Ms Claire Muir  
Town Planning Advisor  
1 Reserve Road  
St Leonards NSW 2065

24/06/2021

**UNSW Health Translation Hub (SSD-10822510)**  
**Response to submissions**

Level 08	
scale	1 : 250@A1
drawn	TH
checked	JC
project no	190551.00
drawing no.	DA1009
issue	D

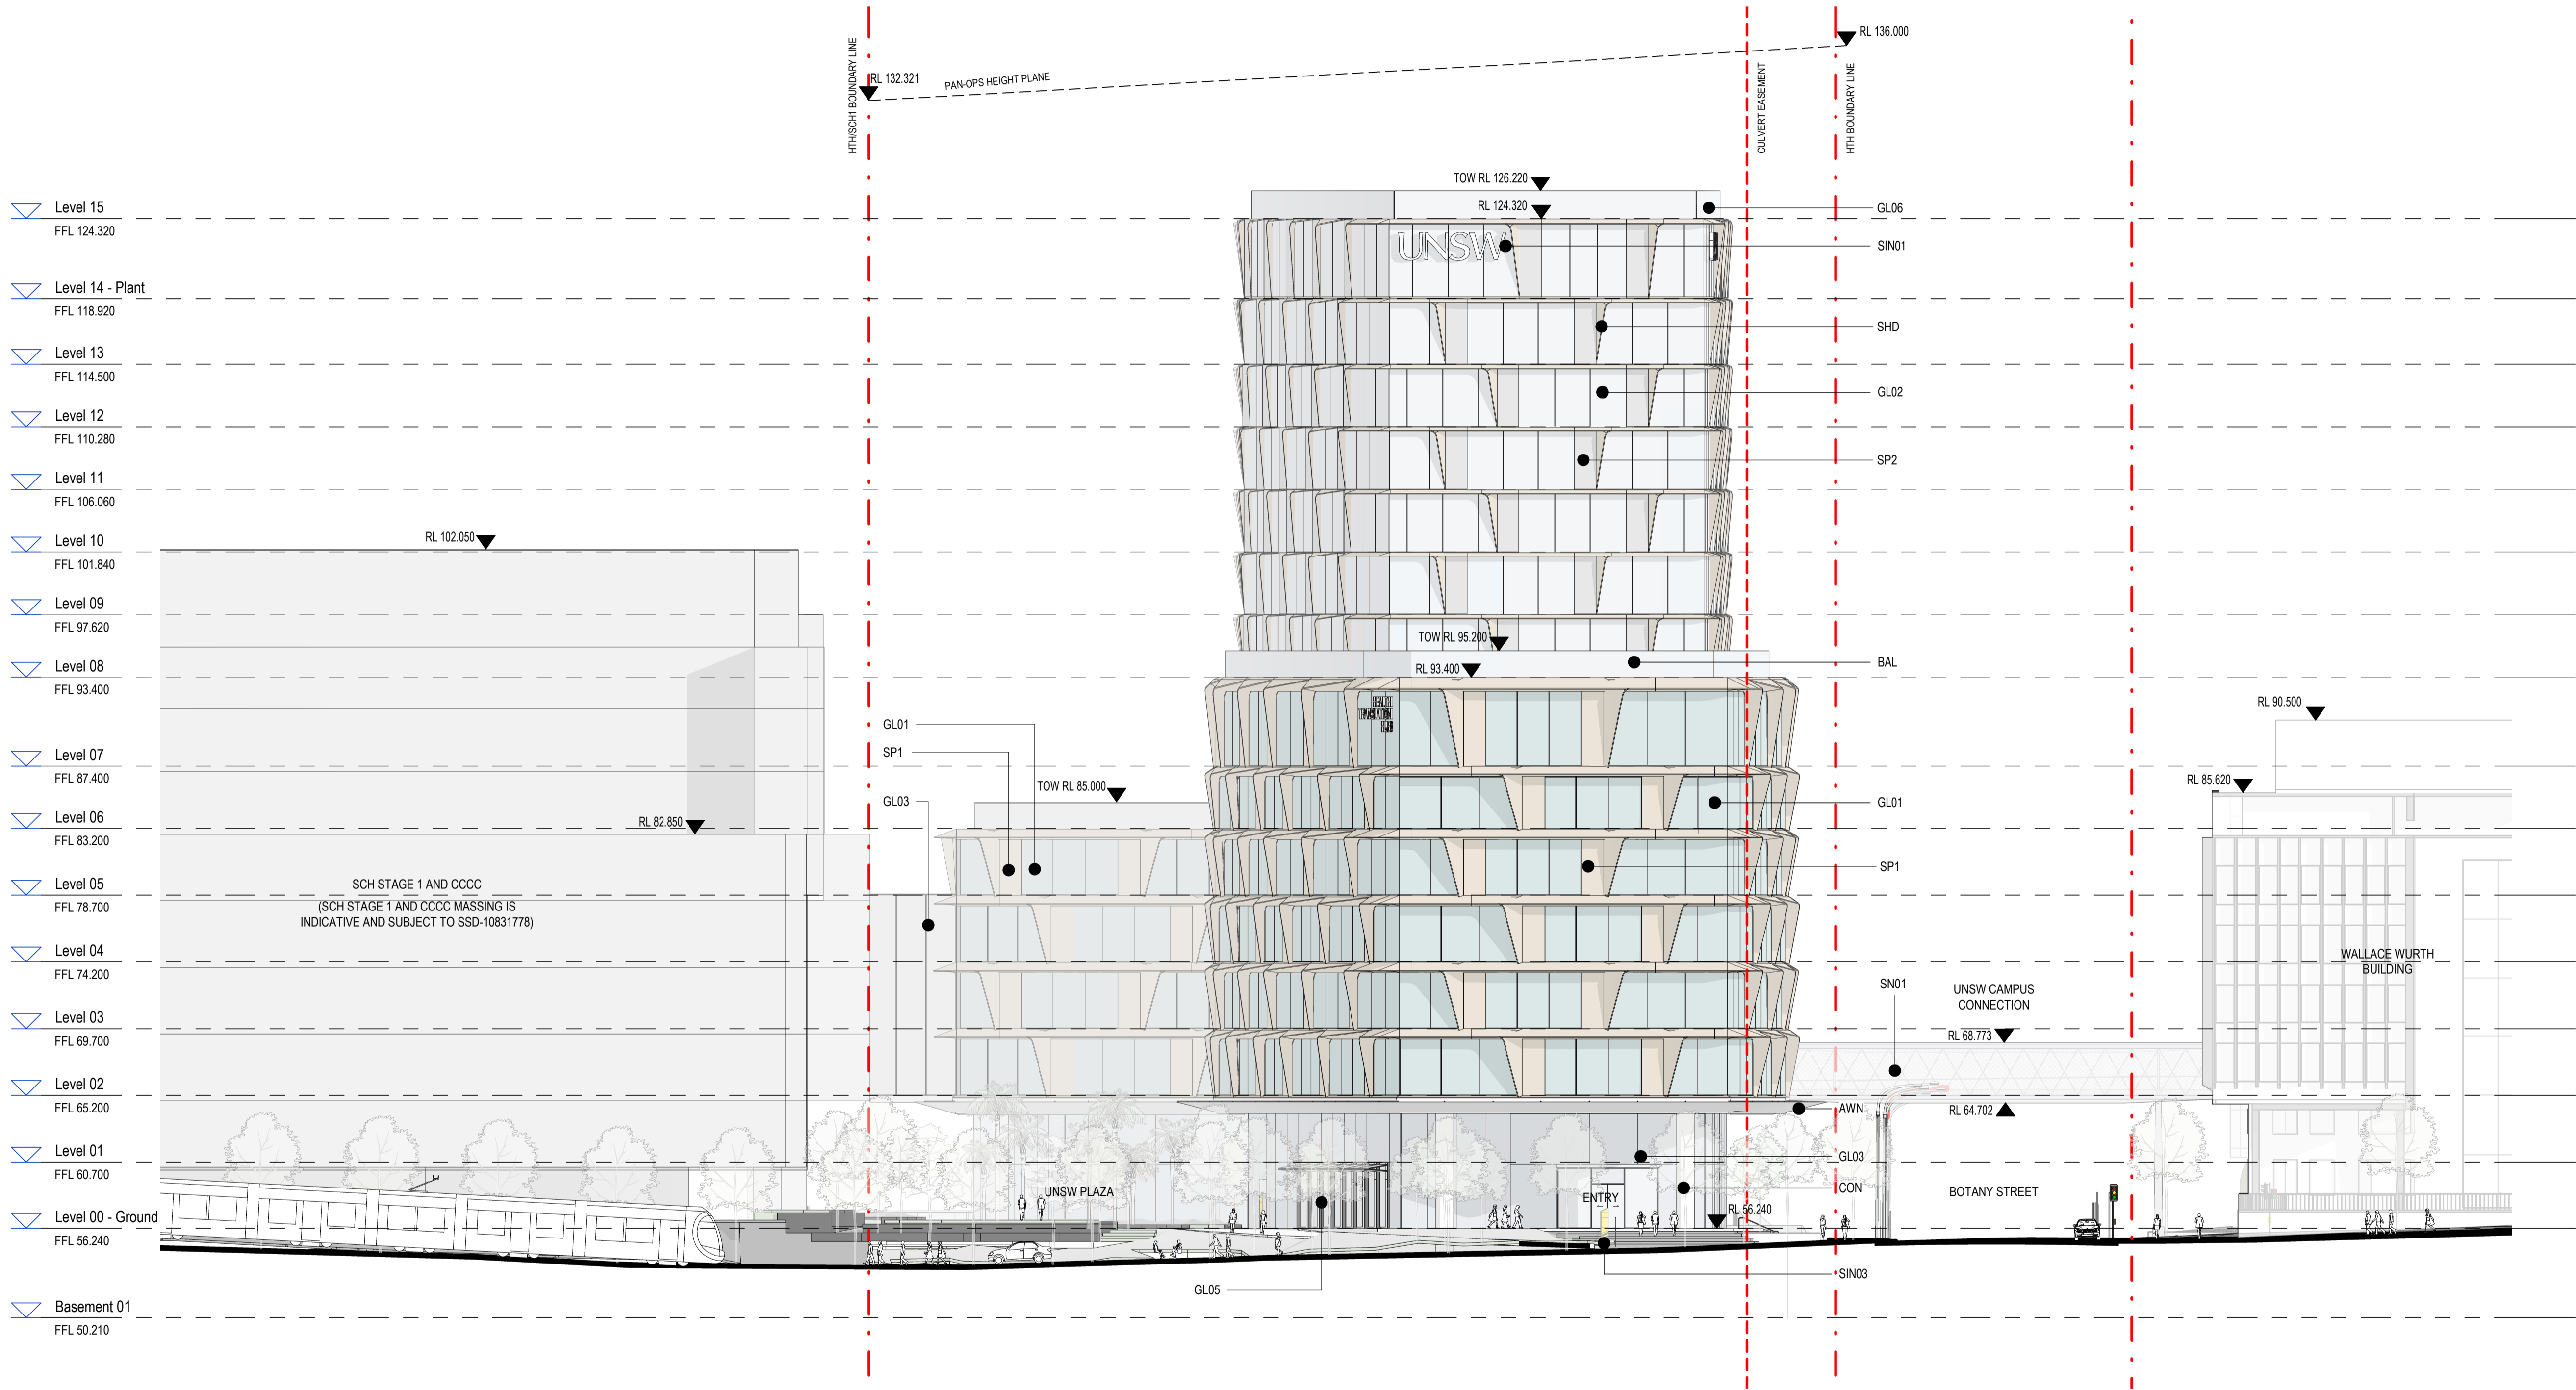
- Further consideration should be given to the provision of outdoor roof terraces to provide amenity for occupants as well as opportunities for outdoor learning or breakout spaces. GANSW have advised that “no access to outdoor learning or breakout spaces is considered a poor outcome”.

- include any proposed landscaping of terraces or podium roof levels.
